**KIRKLEES METROPOLITAN COUNCIL  
INVESTMENT & REGENERATION SERVICE**

**DELEGATED DECISION TO DETERMINE PLANNING APPLICATIONS**

| Site Address:         | Land rear of, Yorkshire House, South Street,<br>Dewsbury, WF13 1JT |
| Description:          | Erection of hotel (within a Conservation Area)                     |

East Elevation As Proposed
 Scale 1:100
 0m 1m 2m 3m 4m 5m

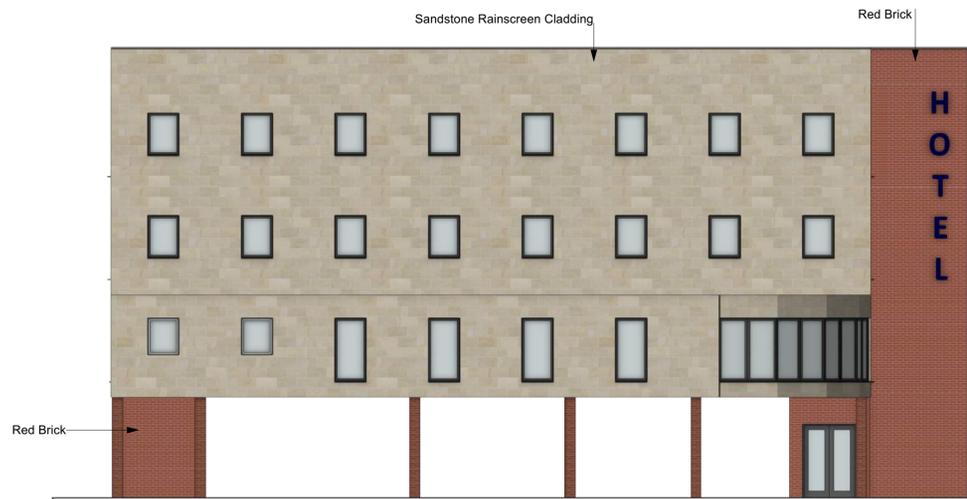
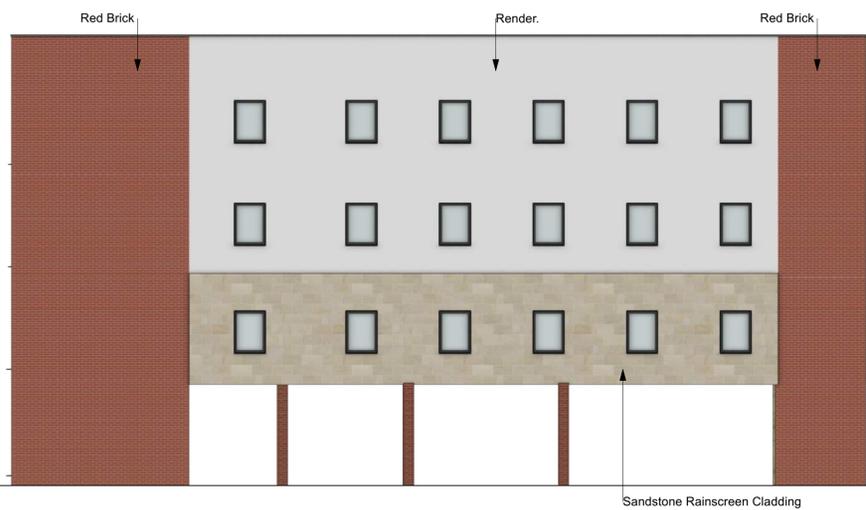
In this instance, the form and layout of the building has little merit in terms of its shape as it largely resembles a rectangular cube owing to its flat roof which, in combination with a lack of articulation or texture to the façade, is inferior to similar mid-20th Century development immediately adjacent at Yorkshire House, 6 School Street and 47 Daisy Hill. These concerns are also considered to be greater when considered within the context of the more traditional buildings, such as 63 Daisy Hill and the Howland Centre which, though more classical in style, provide positive character elements within and adjacent to the Conservation Area.

Ground Floor Site Plan As Proposed  
Scale 1:100  
0m 1m 2m 3m 4m 5m

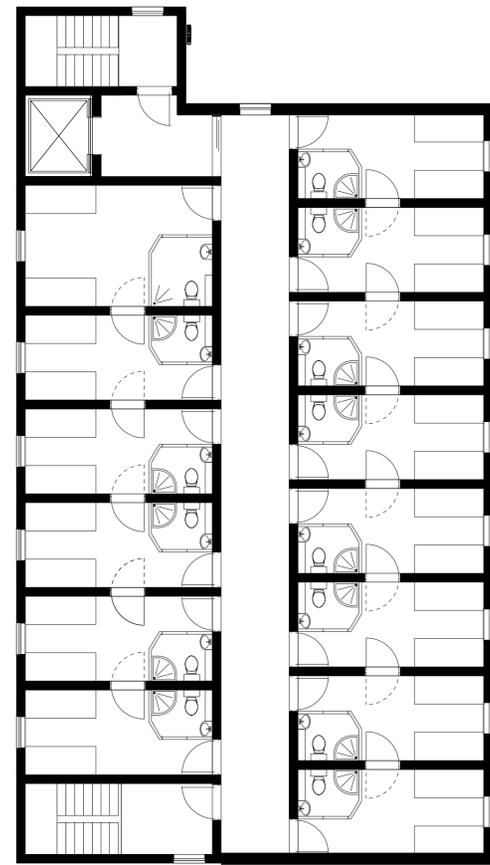
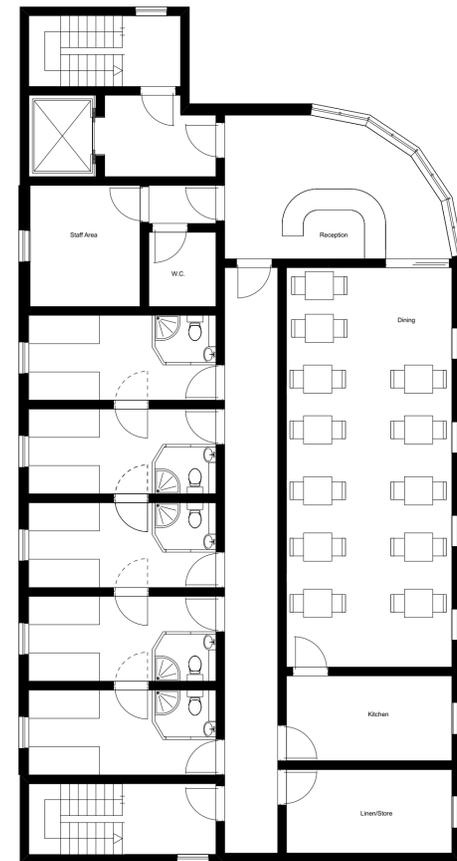
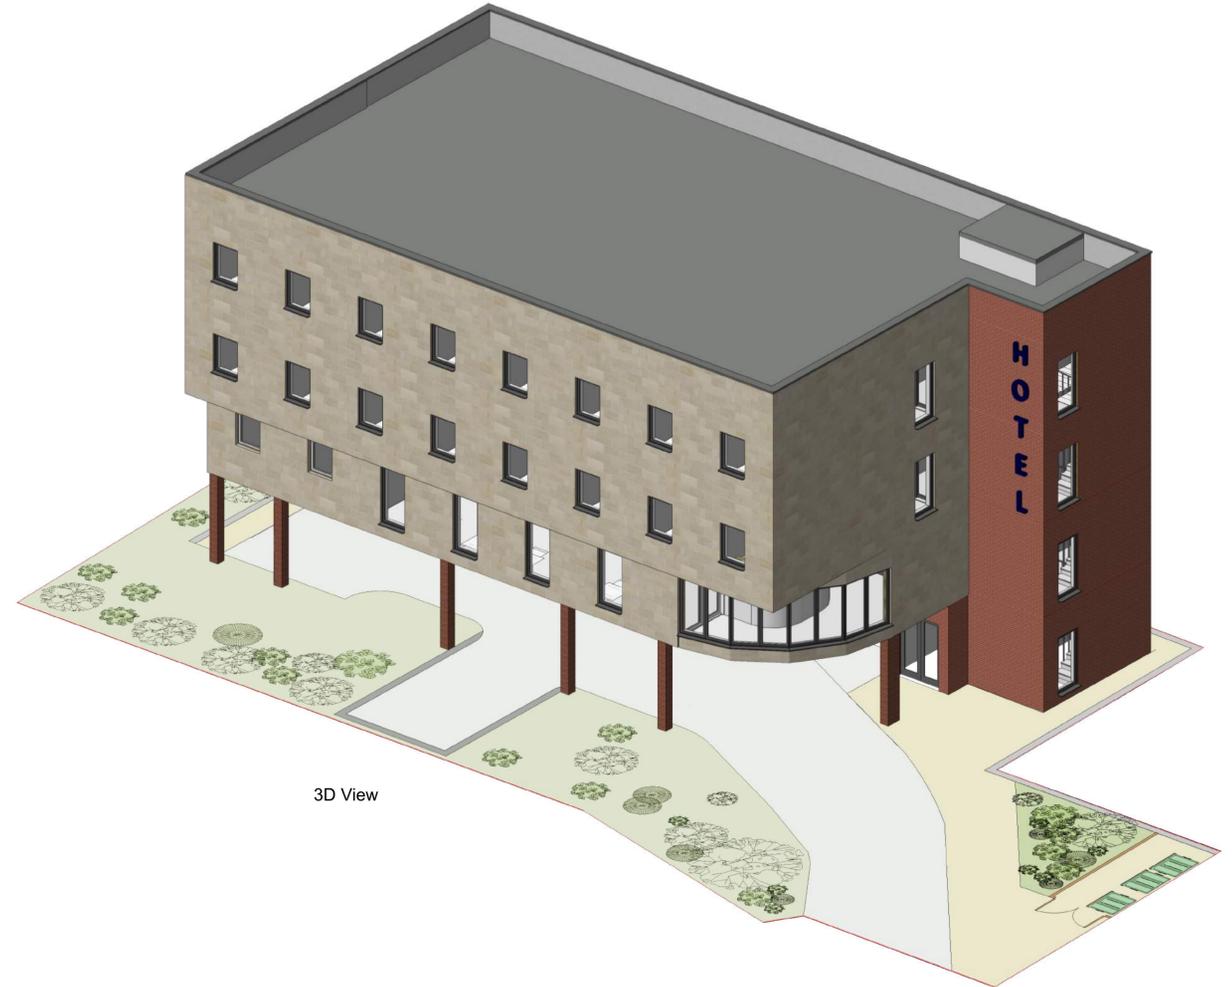
**KC Highways Development Management** – Highways Officers are unable to support the proposals as submitted. The proposals would result in an unacceptable loss of parking. Required details include swept path analysis to demonstrate that a 11.85m long refuse vehicle can reverse into the site without obstructing the flow of traffic along School Street.

**KC Waste Strategy** – Waste Strategy raise concerns in respect of how a Refuse Collection Vehicle would enter the site safely, noting that any proposals should consider the potential impact on pedestrians and motorists when waste collection is occurring at the site.
